Our Case Number: ABP-322242-25

Date: 26 March 2026

Re: Proposed works at Bruree bridge, Co. Limerick.
Bruree bridge, Co. Limerick.

TYPICAL PARAPET WALL SECTION SCALE 1:10

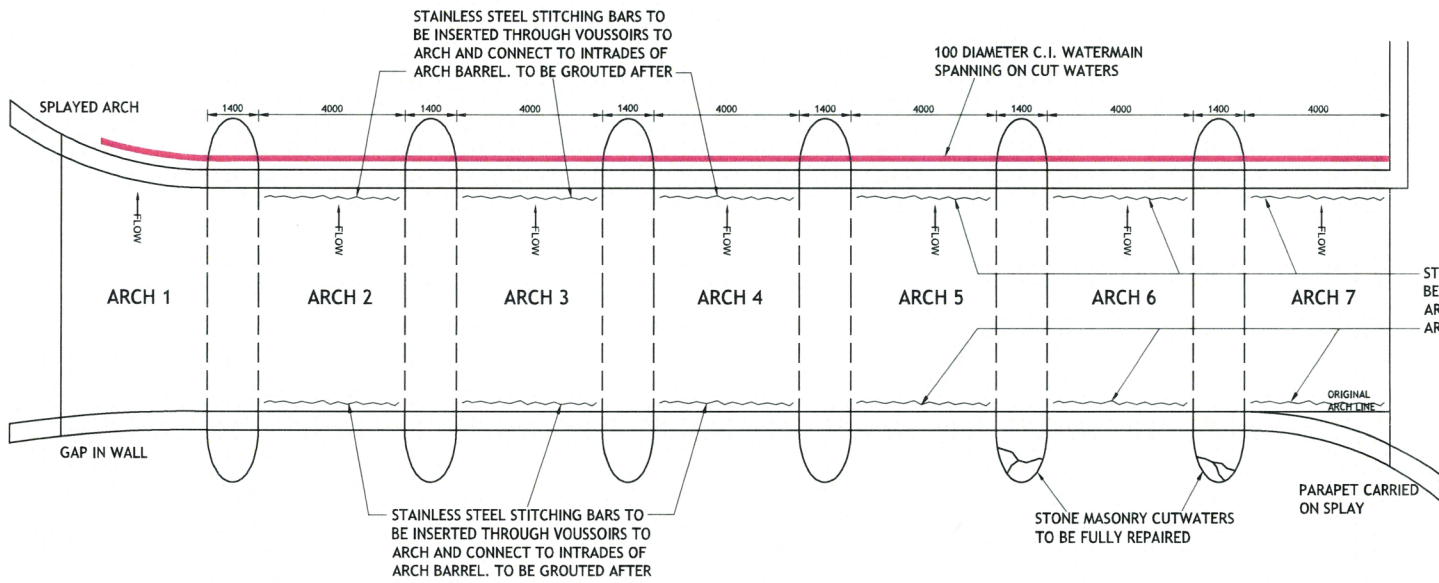
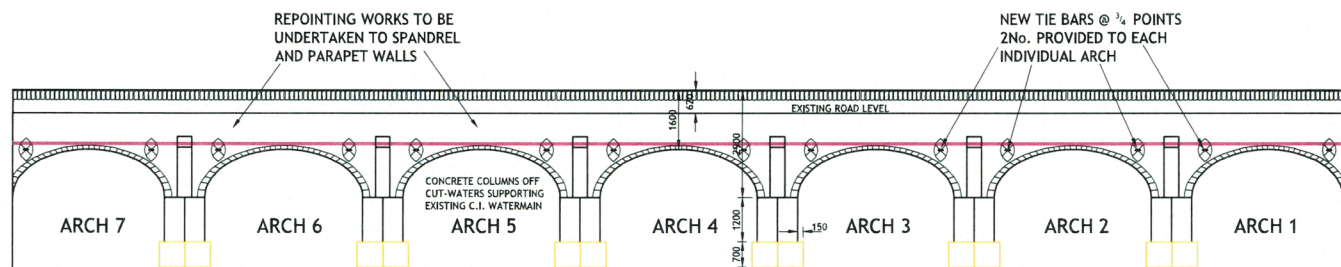
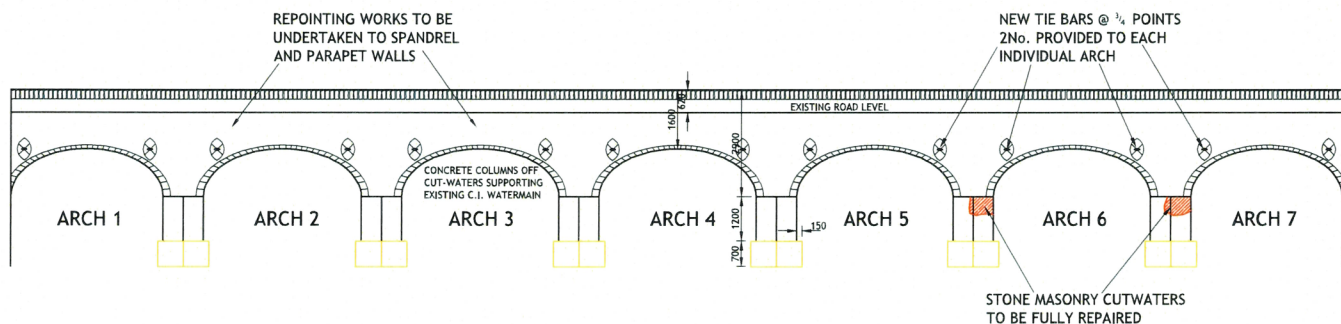
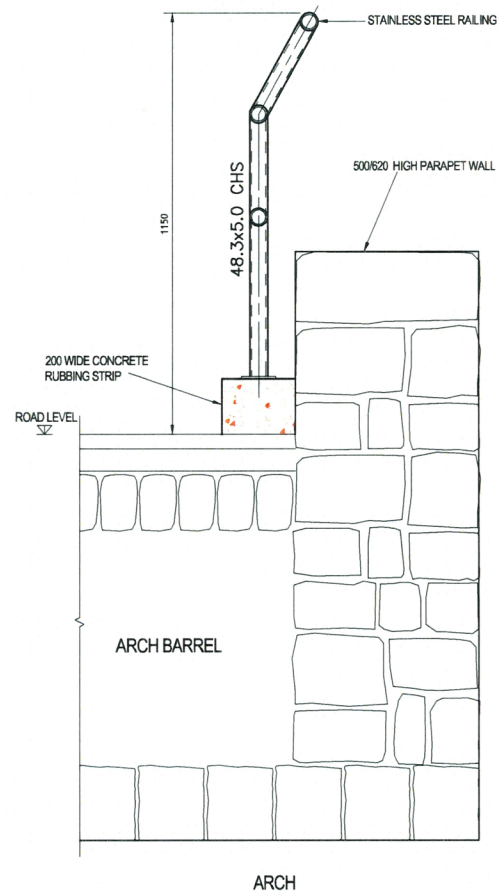
1. Detailed justification for the inclusion of the proposed railings, and their height and design, having regard to the visual and architectural impact on the protected structure and the provisions of the Architectural Heritage Protection Guidelines for Planning Authorities published by the Department of the Arts, Heritage and the Gaeltacht
